**Re: Mandalong Mine Mod 5 – Response to Submissions**

Centennial Mandalong lodged an application and supporting Statement of Environmental Effects (SEE) to modify the State Significant Development consent for the Mandalong Southern Extension Project (SSD-5144). The proposed modification (MOD 5) is seeking an extension to existing longwall panel 24 and the extraction of an additional longwall panel, 24A, within the current SSD-5144 development consent boundary.

### **Response to Submissions – Mandalong Mine MOD 5**

Figure 17 Vertical subsidence along the TransGrid power line at the completion of LW24A

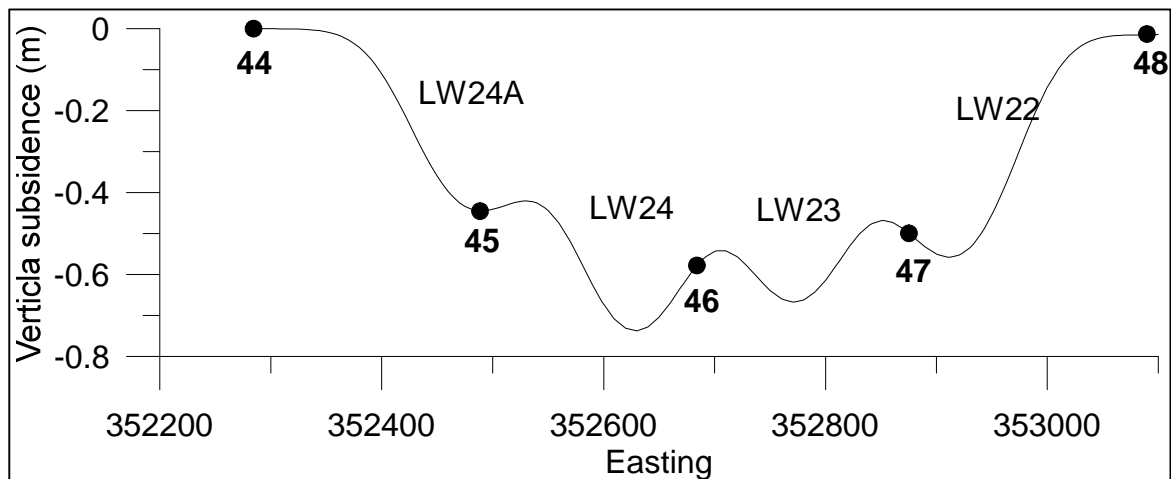
DPE requests additional information / clarification regarding potential subsidence impacts on transmission towers 45 to 47. Section 5 of the Subsidence Predictions Report concludes that predicted strains would have an adverse impact on transmission towers, and that these impacts require "specific attention". However, no further detail is provided and no further mitigation or management measures have been proposed.

It is acknowledged that, based on the subsidence predictions for transmission towers 45-47 inclusive, these towers will require specific mitigation measures to be implemented to ensure they remain safe and serviceable during and after underground mining. Mitigation measures will involve the installation of concrete cruciform footings on each tower to ensure the transmission towers remain safe and serviceable. Centennial entered into a commercial arrangement with TransGrid to design and construct the cruciform footings and construction commenced in March 2017. The installation of the concrete cruciform footings on towers 45, 46 and 47 is now almost complete. The planned completion date for the mitigation work is during August 2017, prior to the commencement of extraction activities within longwalls 22-23 and the proposed 24 and 24A.

These mitigation measures are described in the Transmission Line Management Plan developed in consultation with TransGrid as part of the Extraction Plan for longwalls 22 and 23 and will be further detailed in the Transmission Line Management Plan that will be developed to support the Extraction Plan for longwalls 24 and 24A.
